Reference No:	2025/65/90113/E
Site Address:	Providence Place, Bradford Road, Cleckheaton, BD19 3PN
Description:	Listed Building Consent for internal and external alterations
Recommending Officer:	Edward Cheseldine

DECISION – GRANT LISTED BUILDING CONSENT

2025/90113 - Providence Place, Bradford Road, Cleckheaton, BD19 3PN

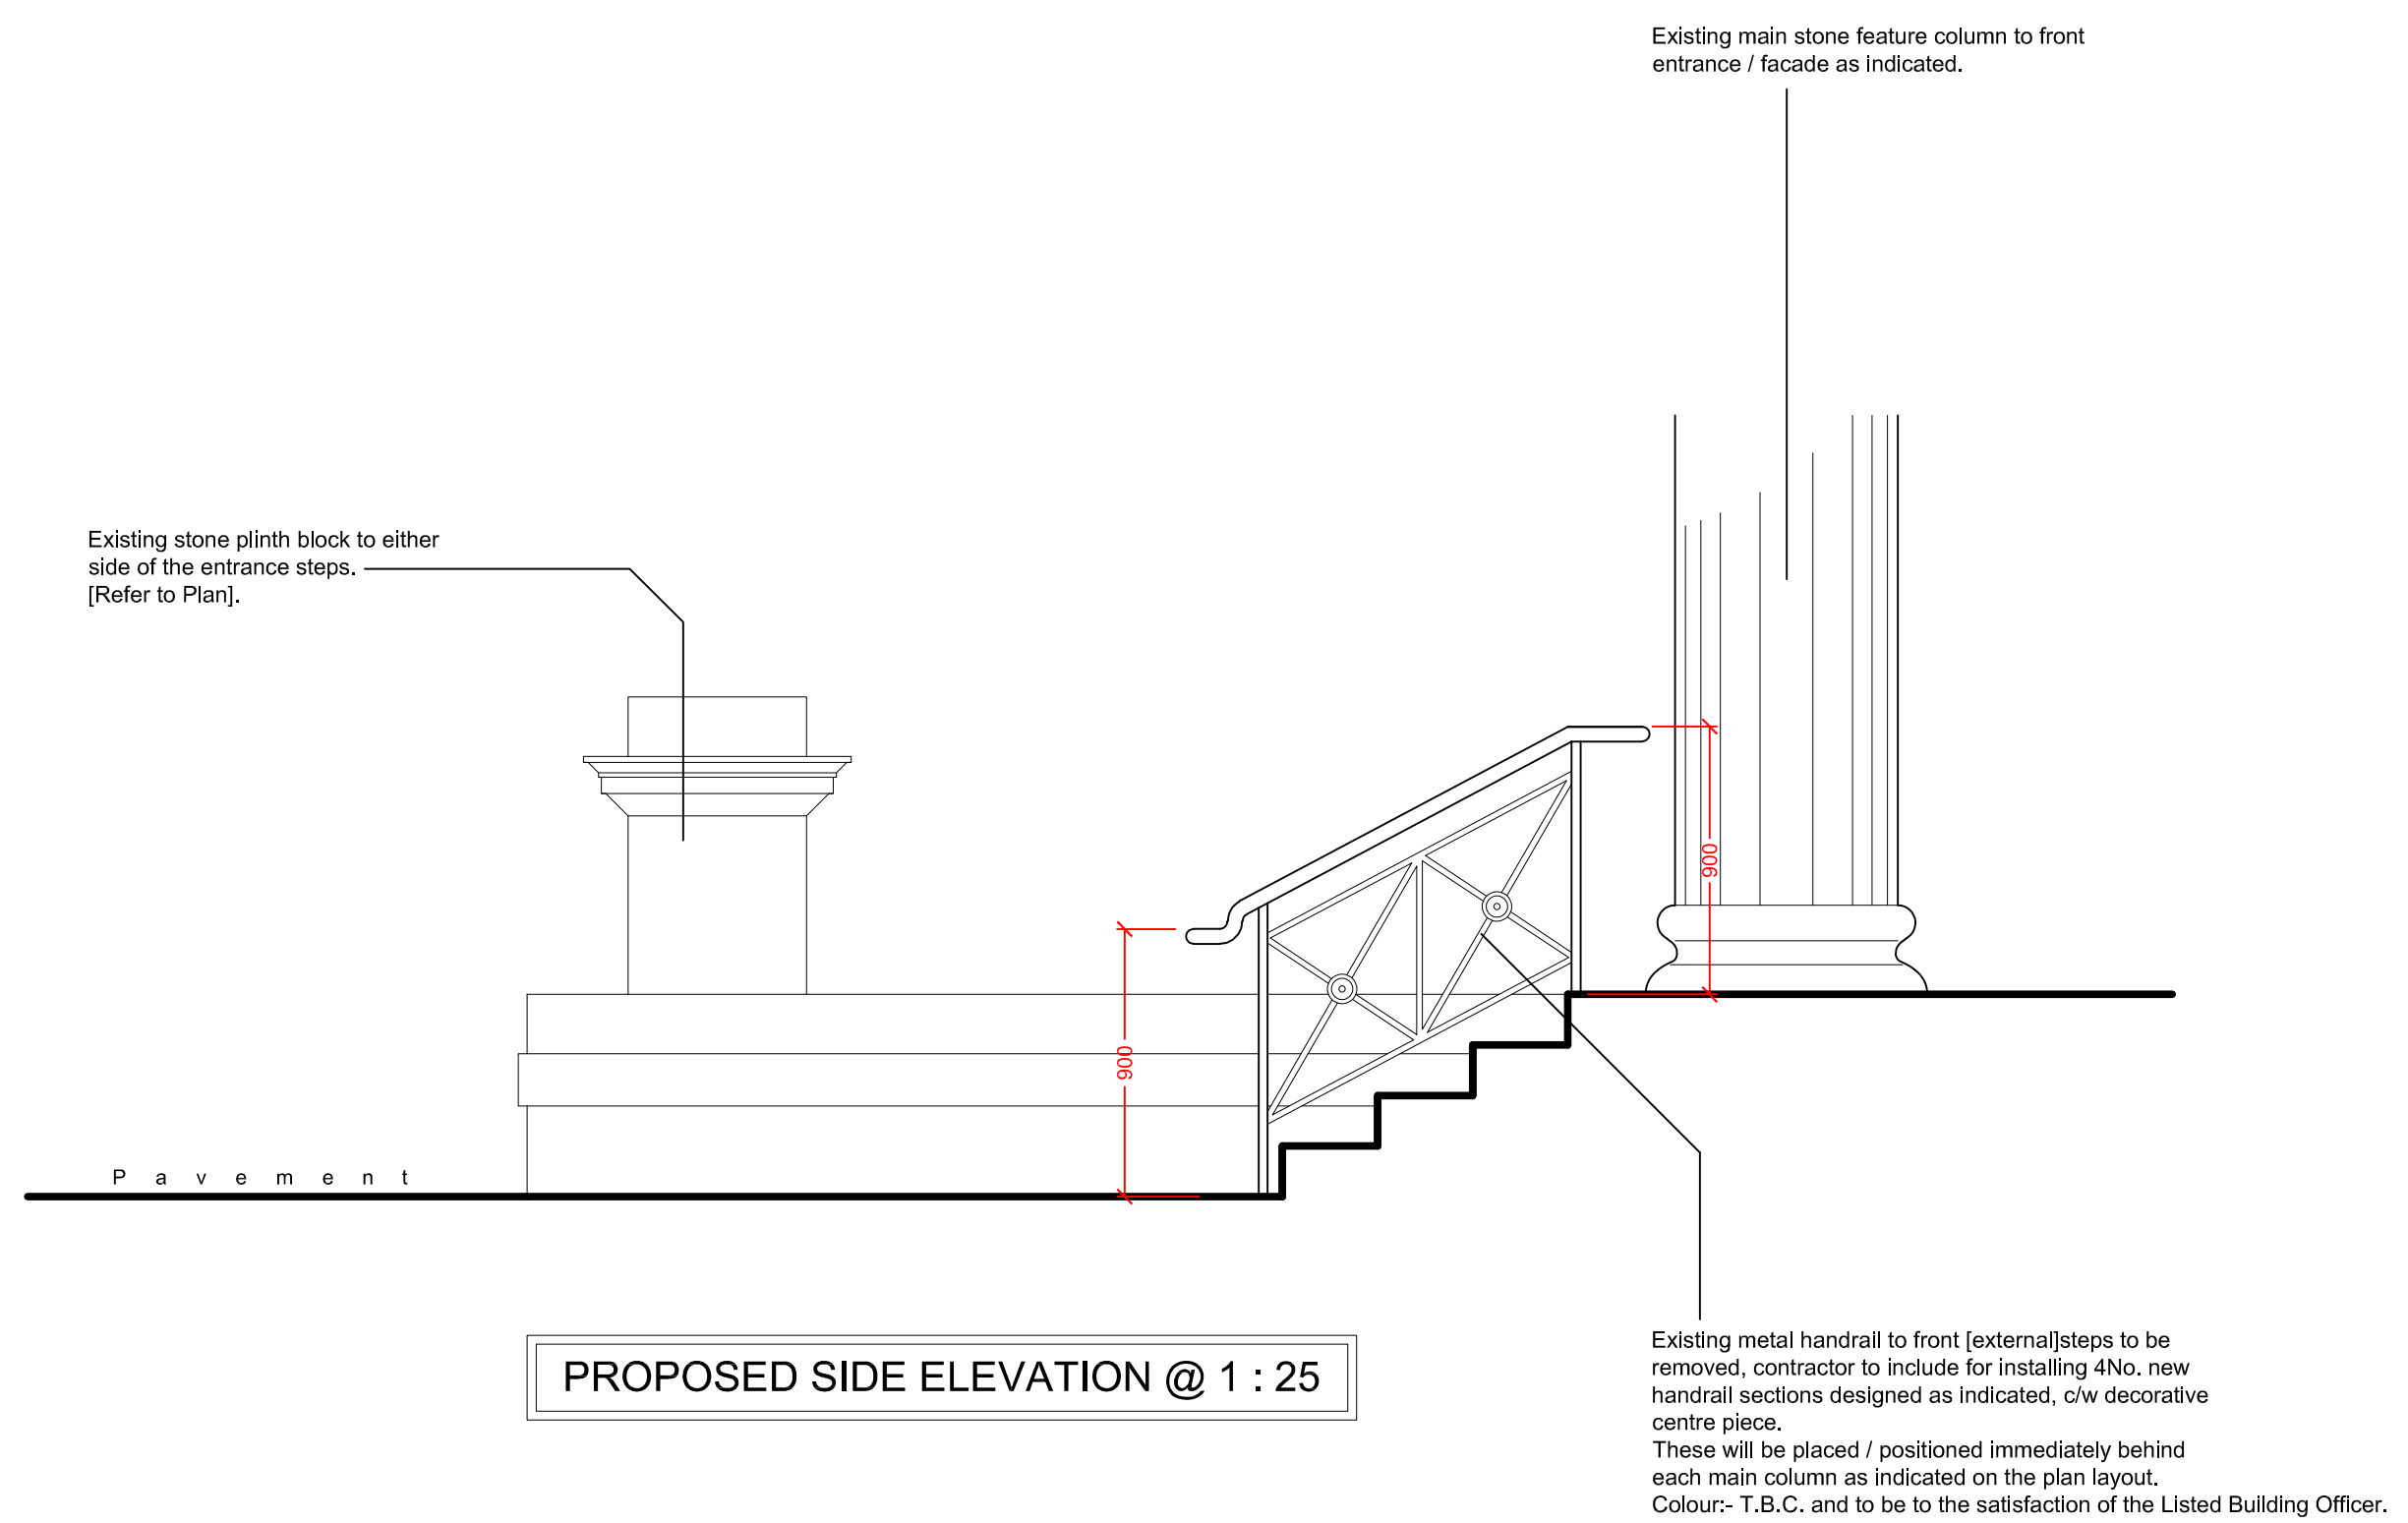
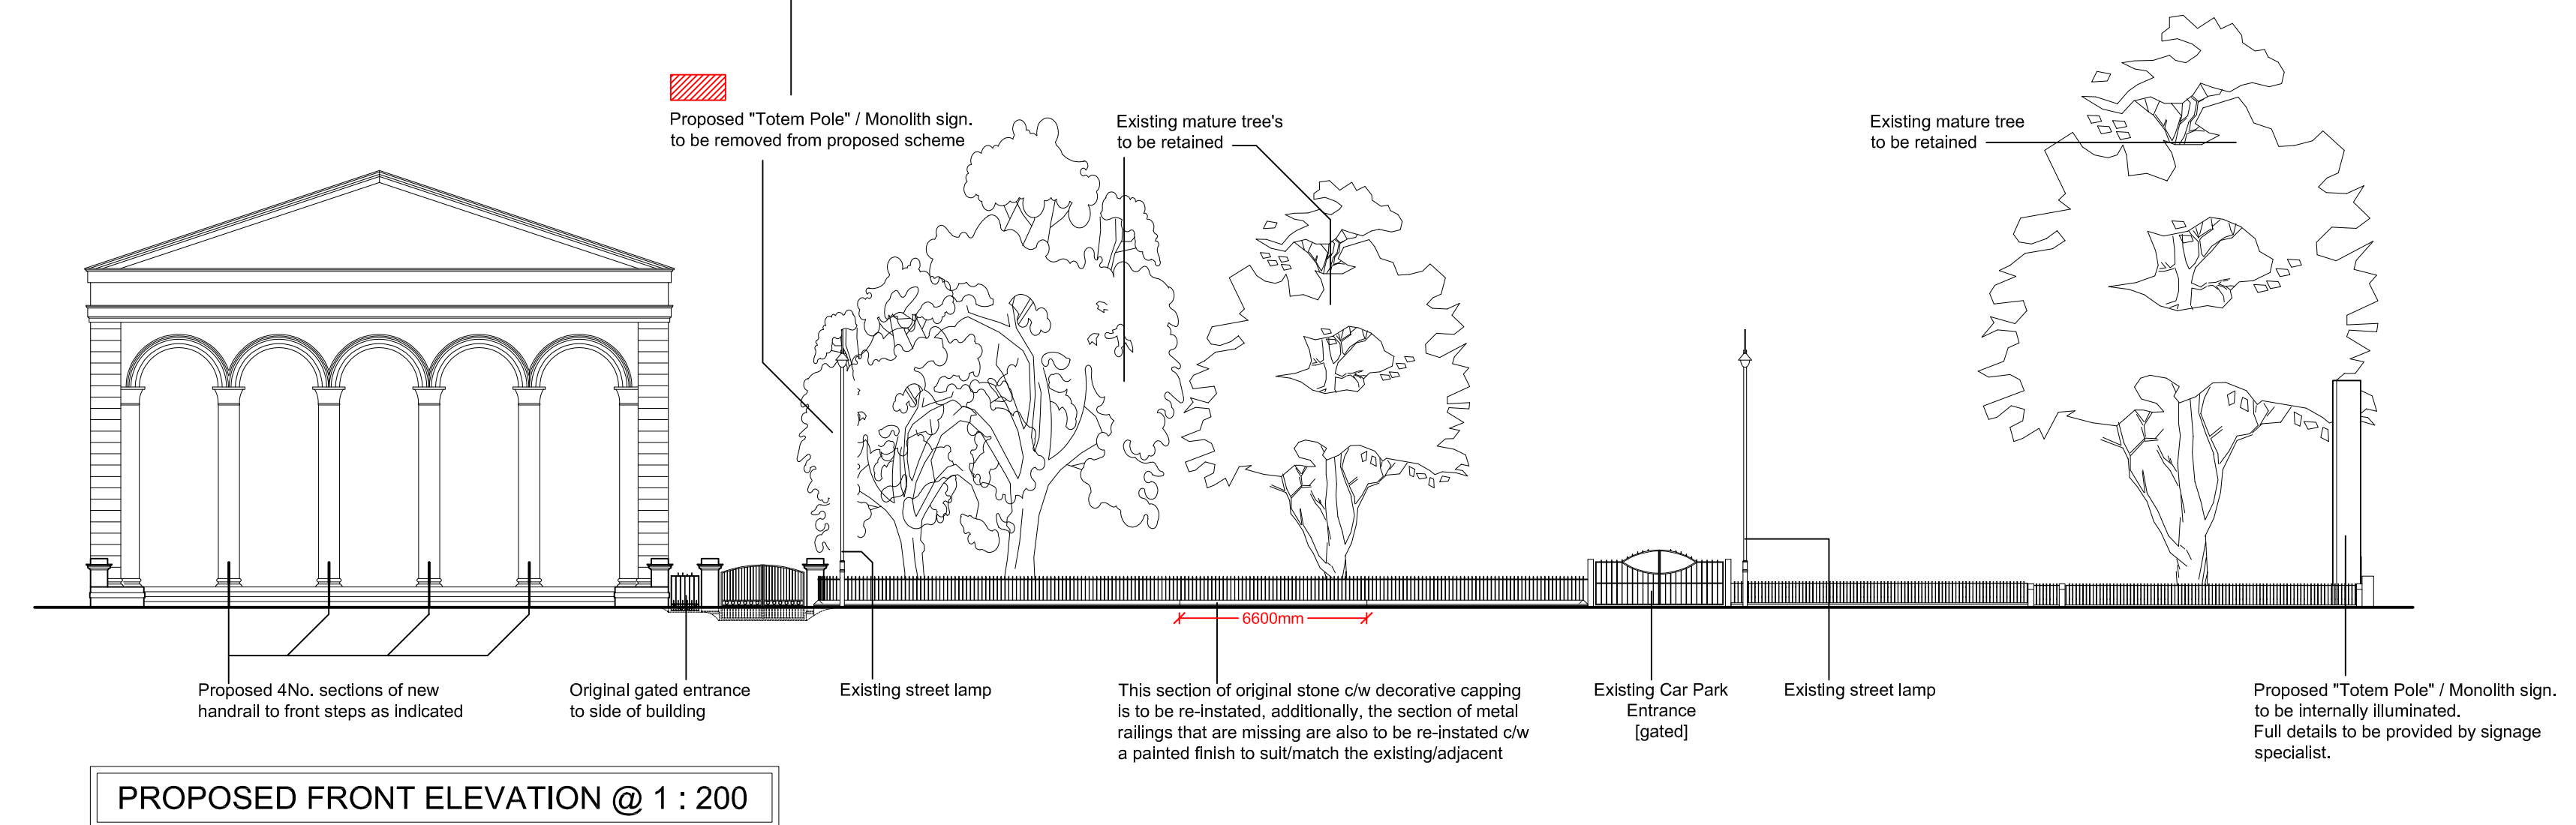
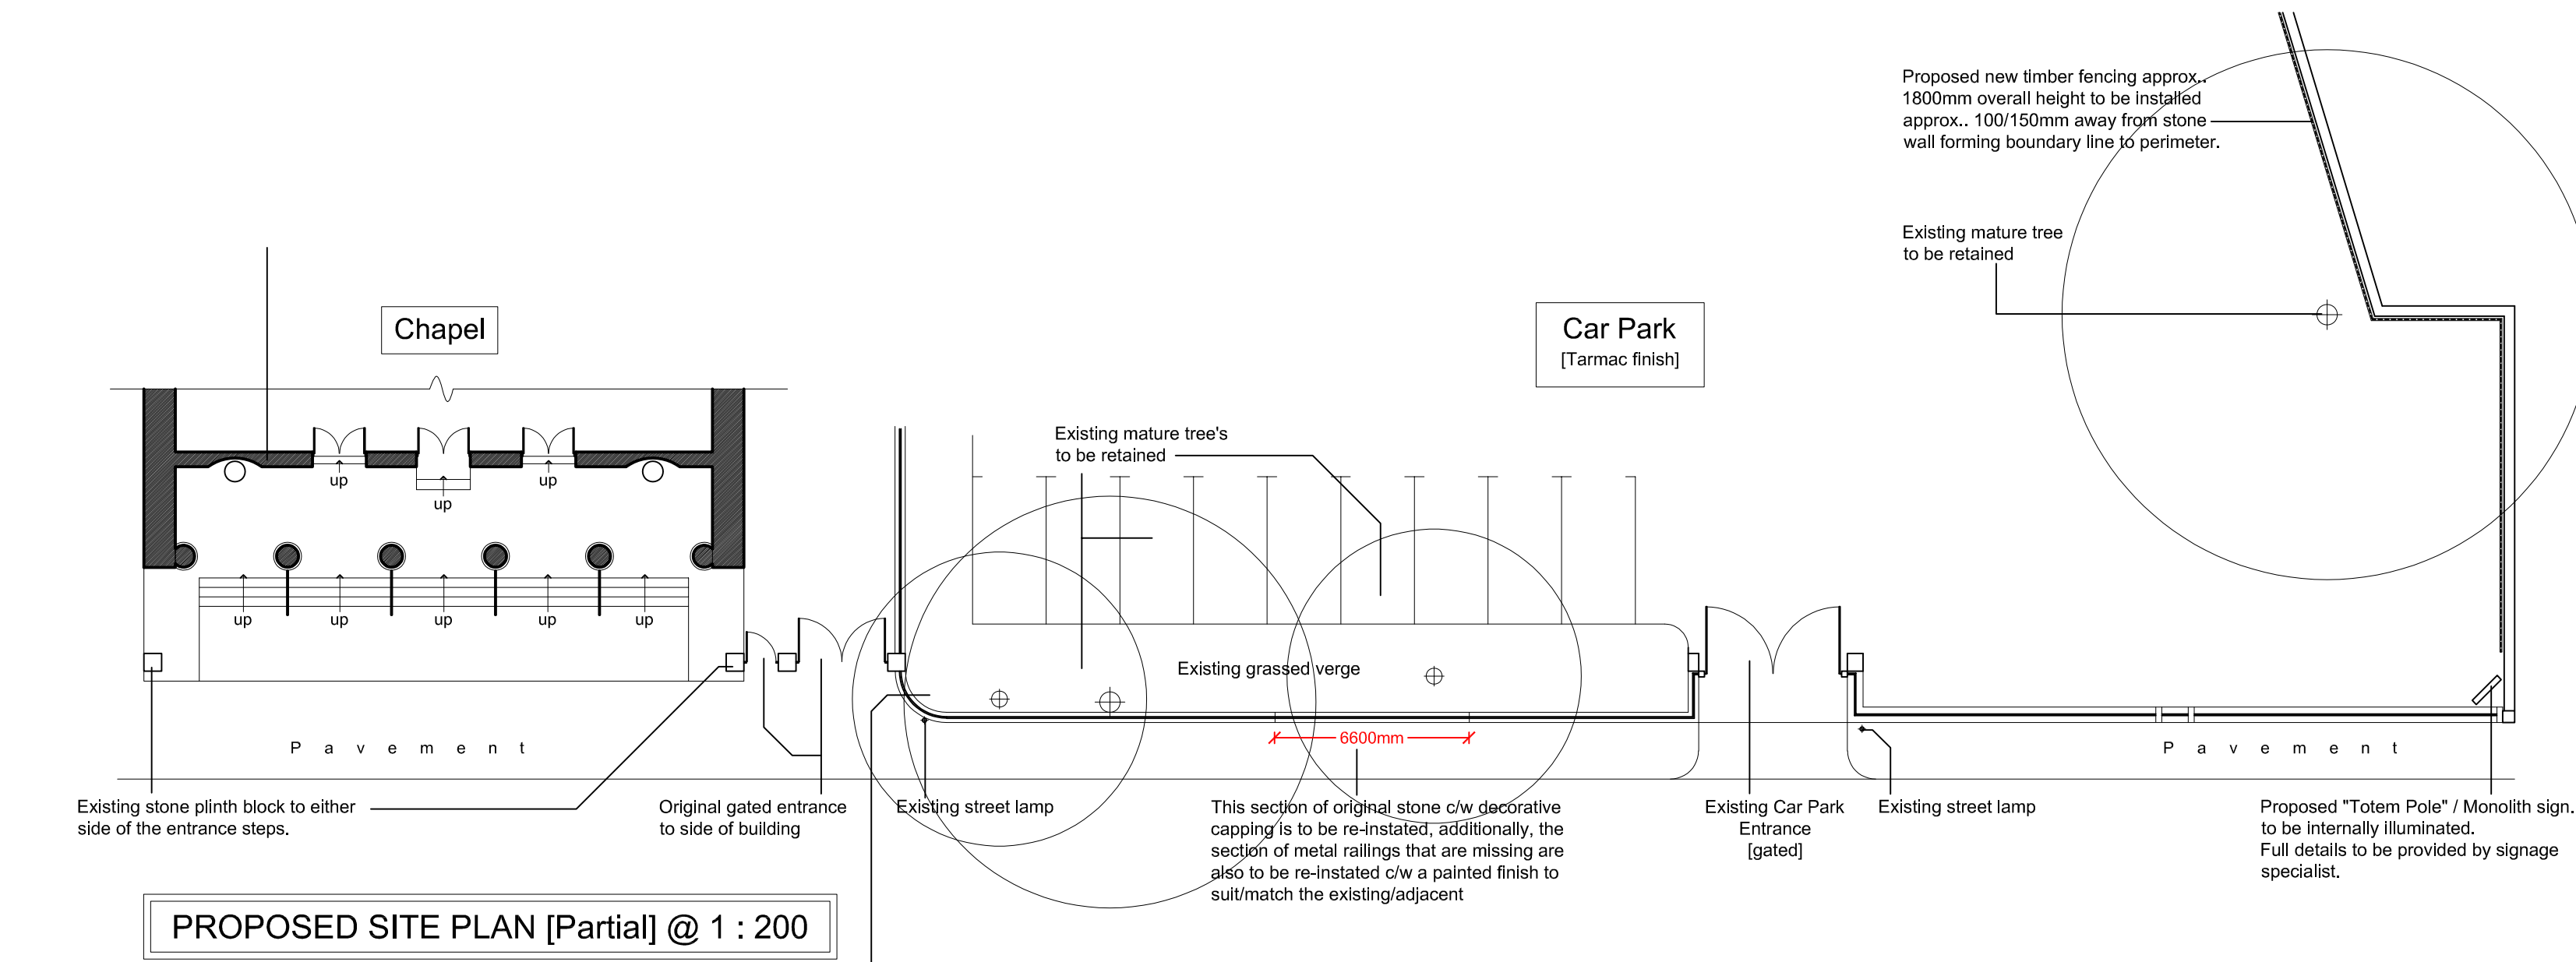
4. Notwithstanding the details shown on the submitted drawing CJ/24/002/C, the stone capping and pointing to the front boundary hereby reinstated, shall in all respects match the appearance of the adjacent sections. Re-pointing shall be carried out using a 1:3 NHL3.5 hydraulic lime:well graded sharp sand mortar.

5. Notwithstanding the details shown on the submitted drawing CJ/24/002/C, the metal railings to the front boundary hereby reinstated, shall in all respects match the appearance of the adjacent sections.

6. The fixing points of all new external handrails (which shall be fixed using non-ferrous fixings) shall be located into the mortar joints and not the face of the stone where practicable.
